Please revise to add a North arrow.

## VICINITY MAP

# Vicinity Map\_V1.pdf Markup Summary

VICINITY MAP

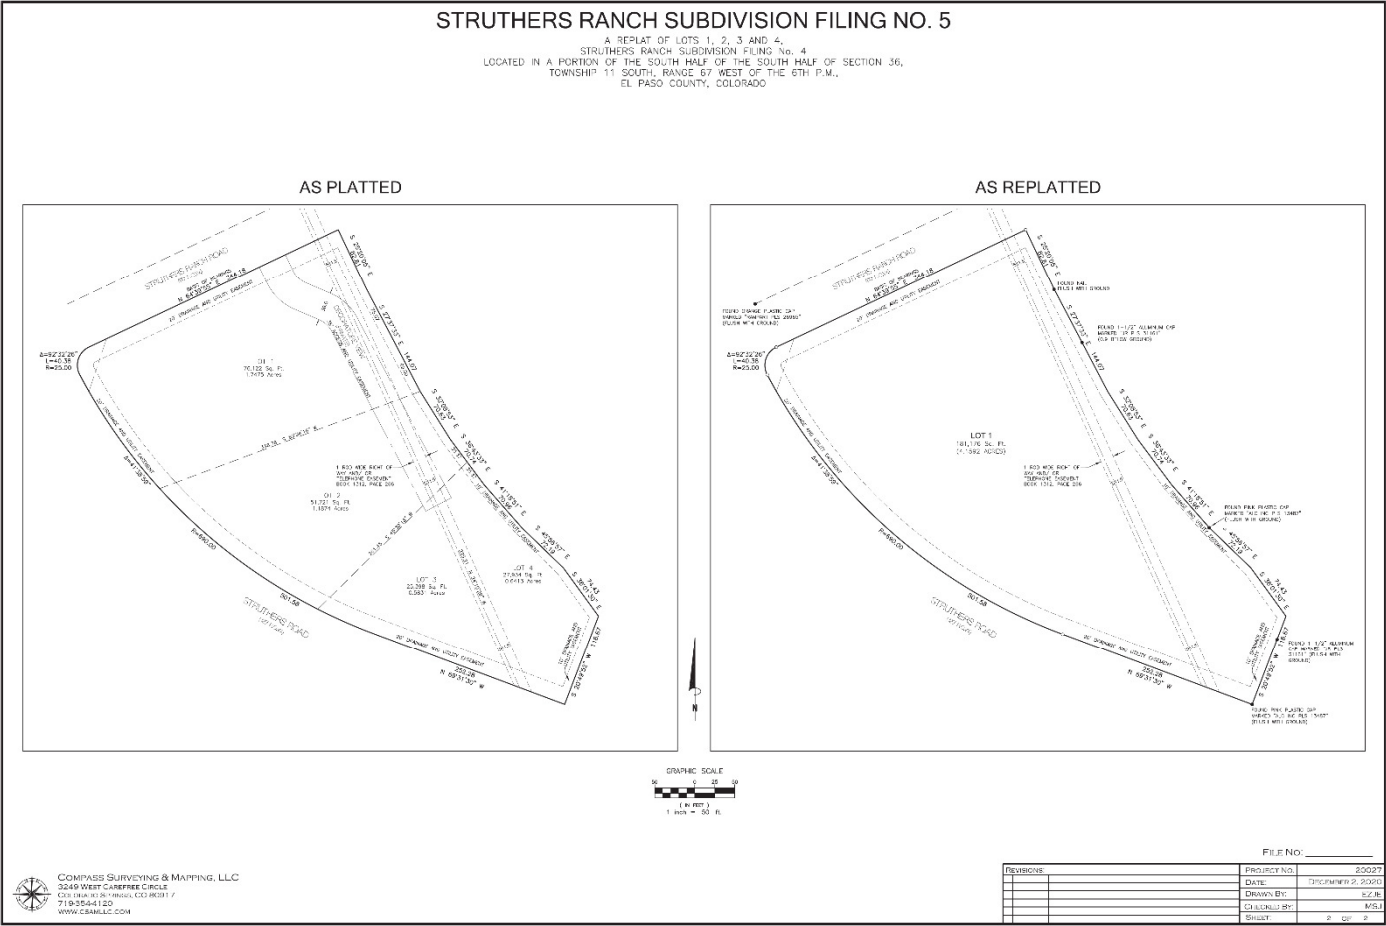
Please revise to add a North arrow.
